Ribble Valley Borough Council
Council Offices
Church Walk,
Clitheroe
Lancashire
BB7 2RA

Phone: 0300 123 6780
Email: Kathryn.Walsh@lancashire.gov.uk
Your ref: 3/2025/0025
Our ref: 3/2025/0025/HDC/KW
Date: 28 February 2025

Location: Middle Studlehurst Barn Osbaldeston Lane Osbaldeston BB2 7LZ
Proposal: Proposed demolition of existing garage and erection of two-storey garage and open sided outbuilding.
Grid Ref: 363996 433284

2073 | 3.02B

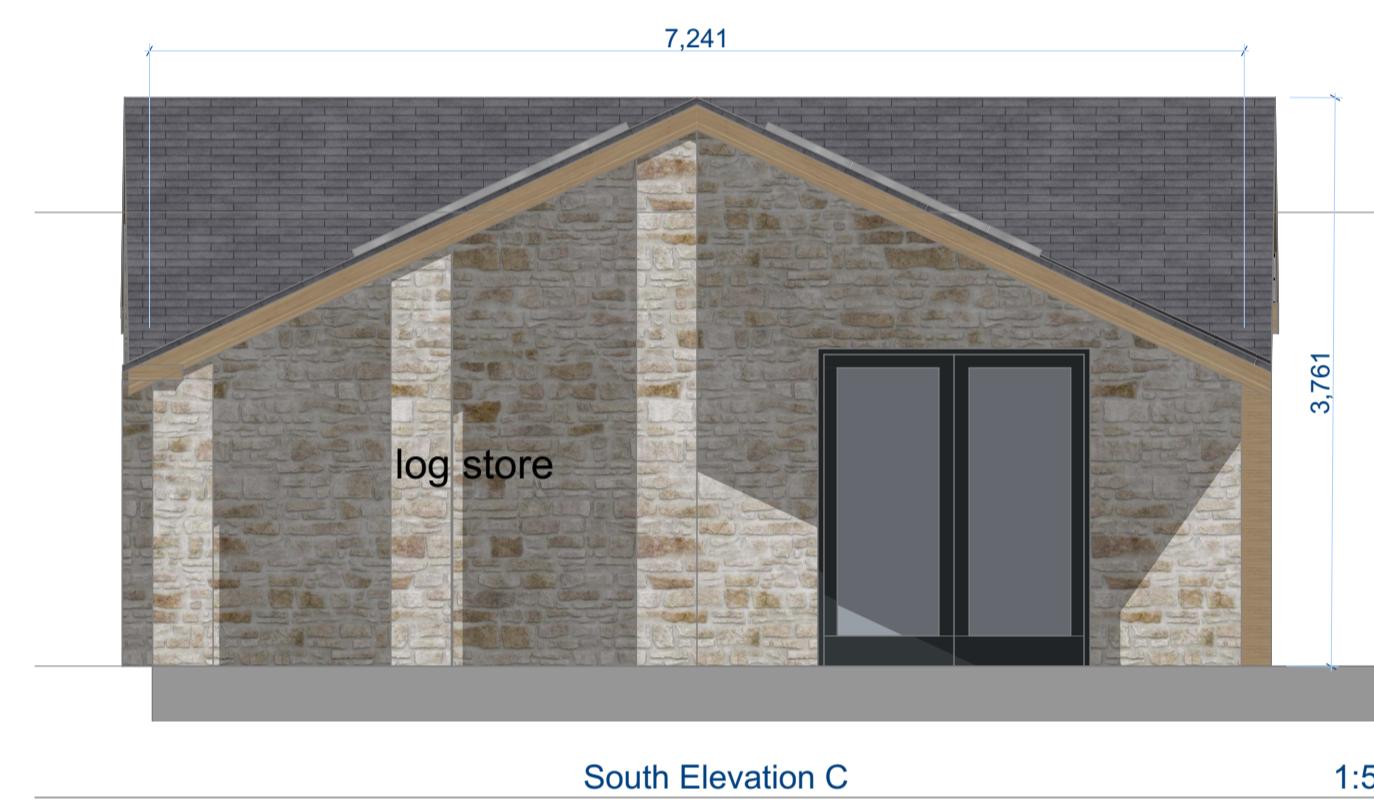
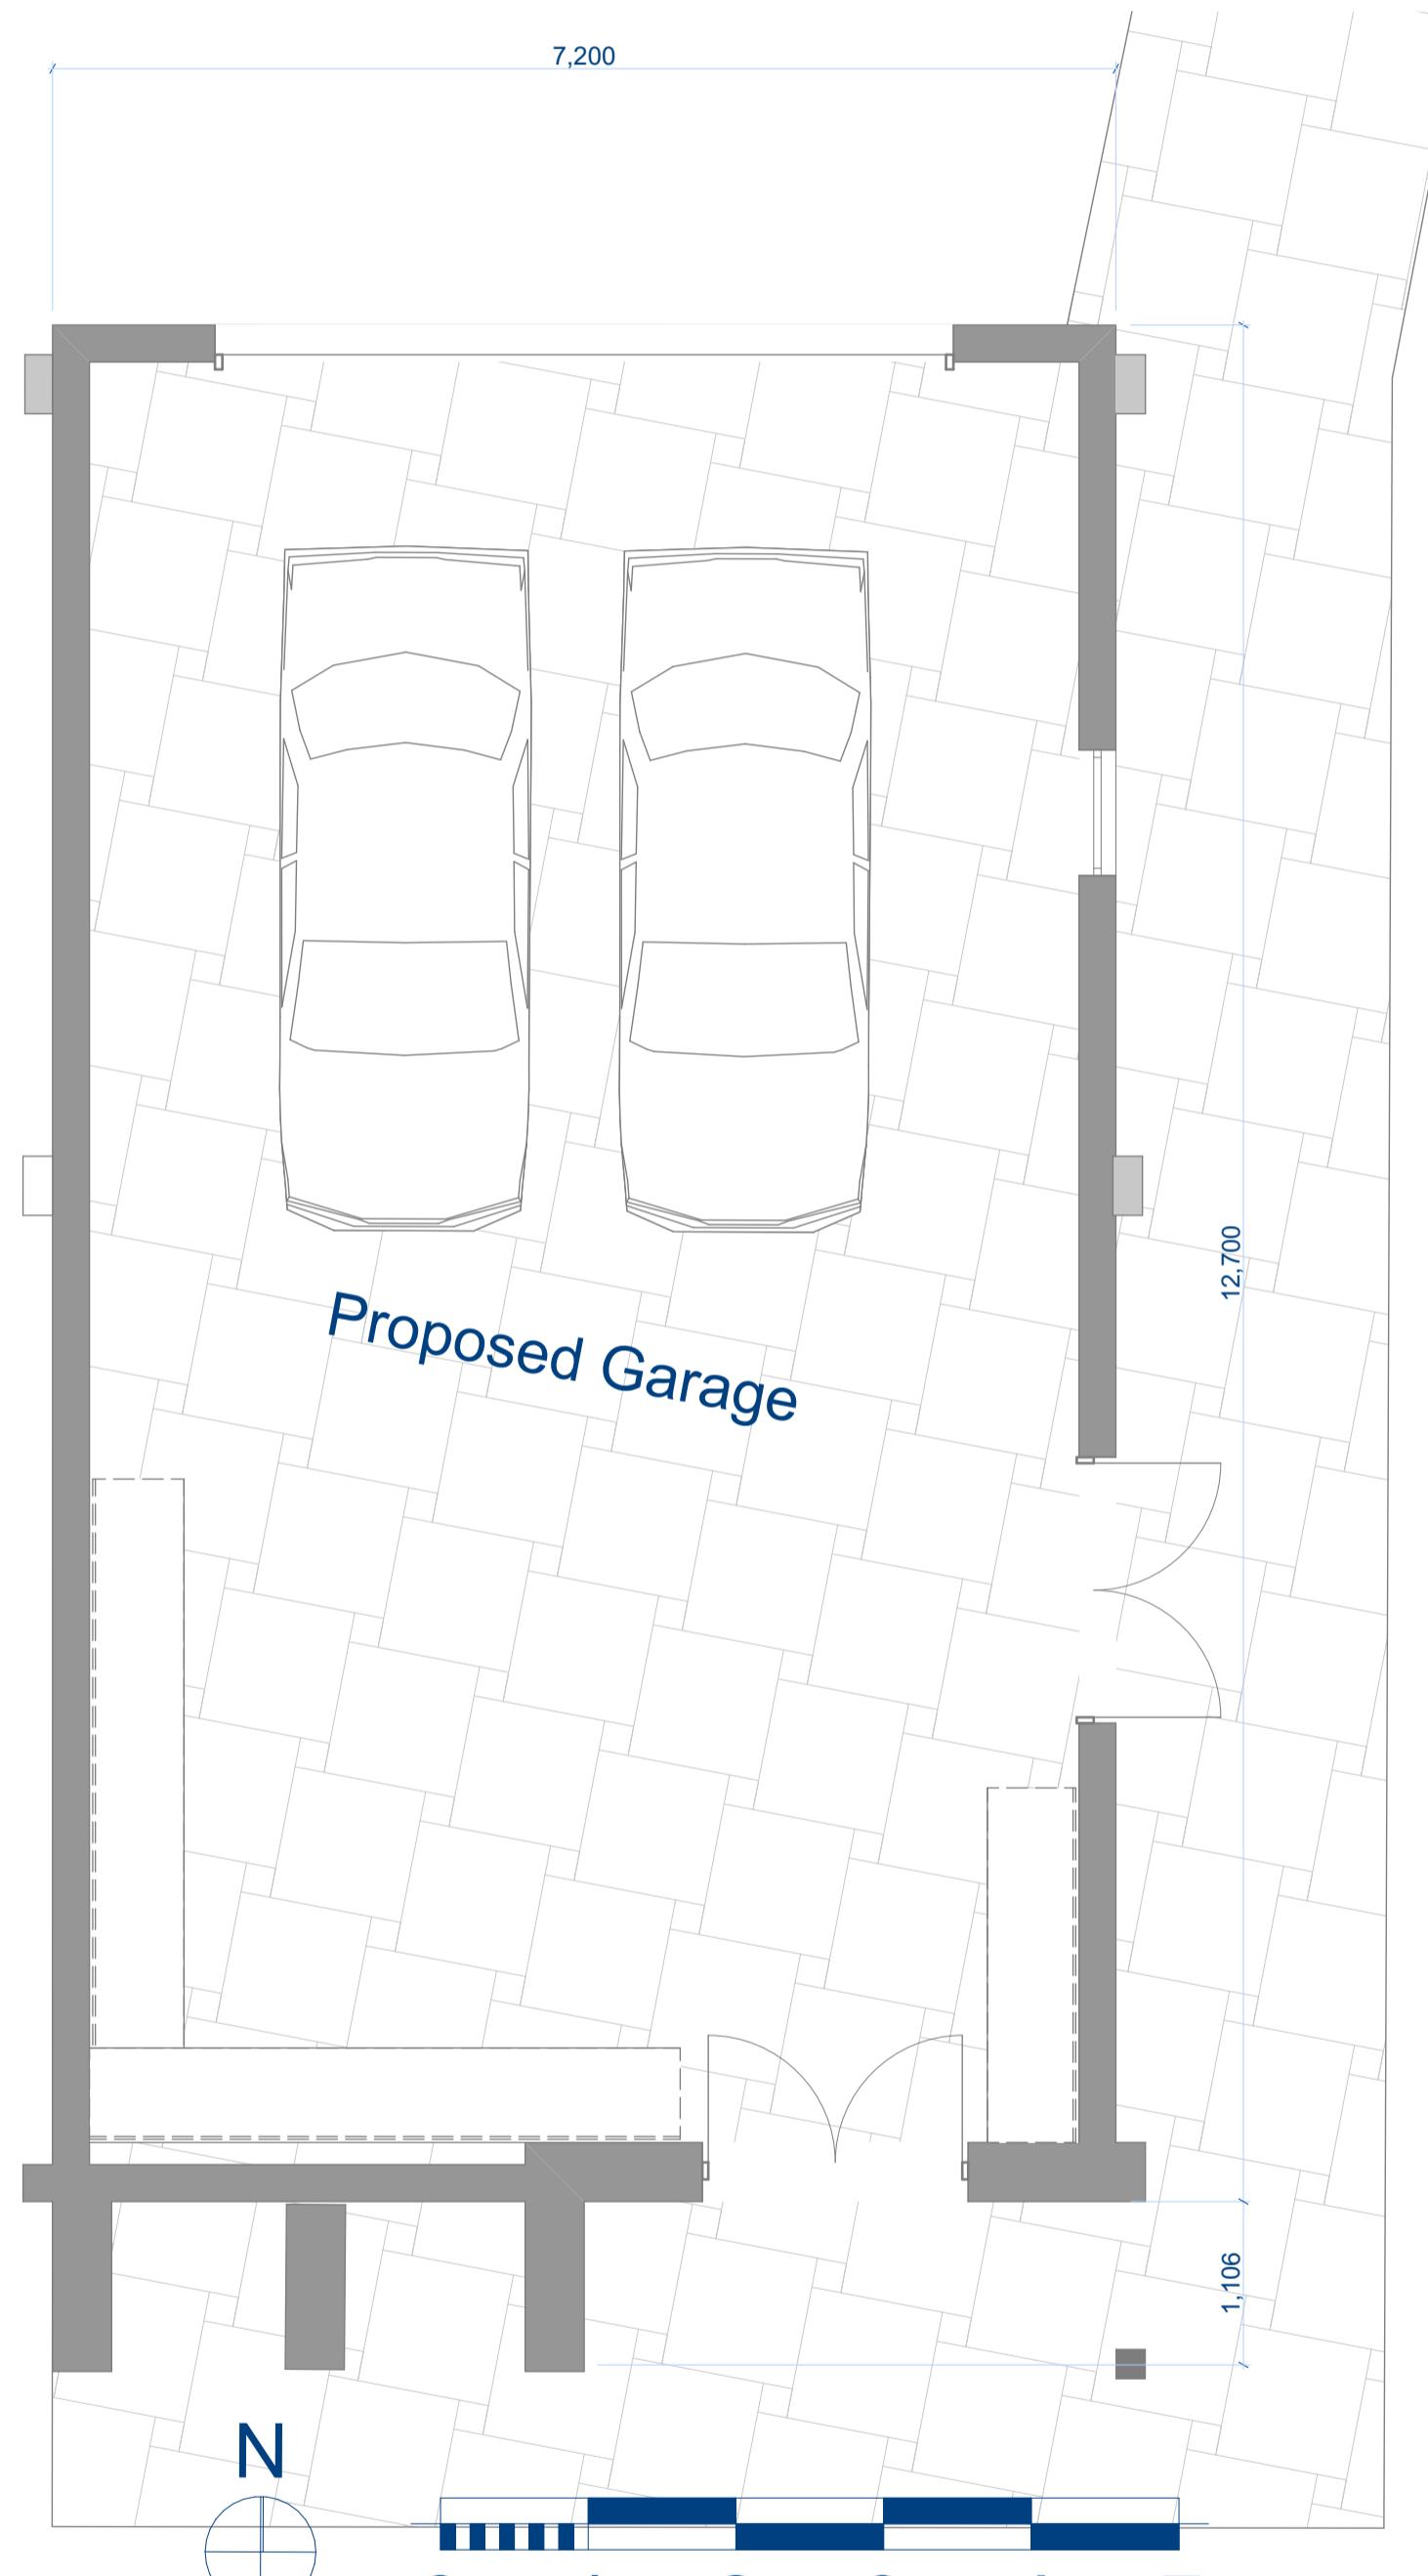
The proposed garage meets the recommended minimum internal dimensions for a double garage which is 6m in length and 6m wide. The recommended distance of 6m is based on the length of a large family car (Ford Mondeo Estate 4.58m long), clearance at the rear of the car (200mm), overhang of the garage door (600mm) and room to stand in front of the car and open/close the garage door (600mm).

1. The garage hereby approved shall be kept available for the parking of vehicles ancillary to the enjoyment of the household(s) and shall not be used for any use that would preclude the ability of their use for the parking of private motor vehicles, whether or not permitted by the provisions of the Town and Country Planning (General Permitted Development) Order 2015 or any order amending or revoking and re-enacting that order.
